Rezoning Transportation Analysis

Petition Number: #2022-089

Revision Log:

Date	Description
11-28-22	First Review (TM)
01-25-23	Second Review (TM)
04-25-23	Third Review (TM)

RZP-2022-089

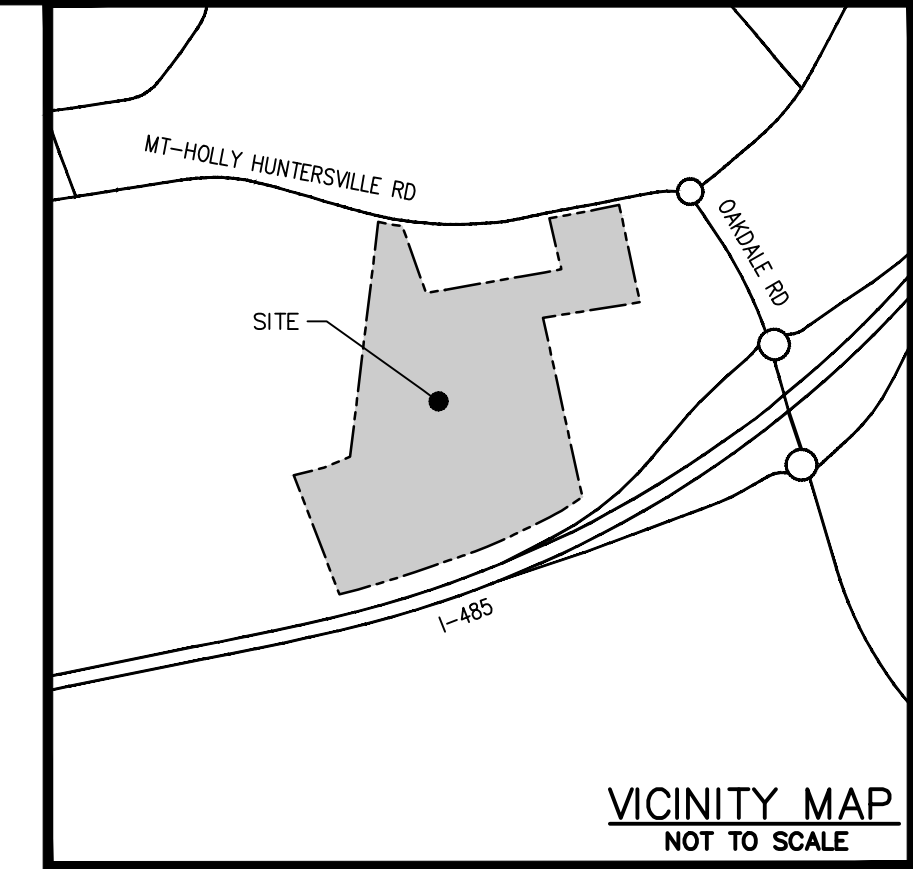
1. **Curbline:** The proposed zoning district has a setback measured from back of the existing or proposed future curbline.
 - a. **Mt Holly Huntersville Road:** The future location of curb and gutter is measured at 30-feet from the centerline of the roadway to the BOC.

Label and dimension the curb and gutter from the centerline for each road on the site plan.

7. Site plan and conditional note(s) revisions are needed to commit private street A, B & C as public roadways. Public street C to stub to the western property line for a future roadway connection. The public roadways are to be designed to CLDSM standards U-03 to accommodate on-street parking. The Right-of-way, curb line and sidewalk are to be dimensioned from the roadway centerline. Add a conditional note committing to the construction of each public roadway.

Clarifying Comment (01-25-23): Add a conditional note committing to the construction of each public roadway. Identify each roadway as U-03 on the site plan and in the conditional note.

New Comment 04-25-23: Remove perpendicular parking from public streets. Parking along public roadways shall be parallel parking as shown in previous submissions. Public streets should be constructed to CLDSM standards including design of on-street parking and sidewalk.

8. **Outstanding Comment from 11-28-22:** Site plan and conditional note(s) revisions are needed to label roadway "B" site access as right-in right-out and roadway "A" site access as full movement. A right-turn lane is required at site access B, site plan shall label and dimension turn lane. A right-turn lane and left-turn lane is required at site access A, site plan shall label and dimension turn lane.

Clarifying Comment (01-25-23): Site plan and conditional note revisions are need to show turn lane improvements as outlined above on the site plan. The site plan shall label and dimension the components of the turn lane. Add a conditional note committing to the turn lane improvements. Coordinate with NCDOT on turn lane storage length requirements.
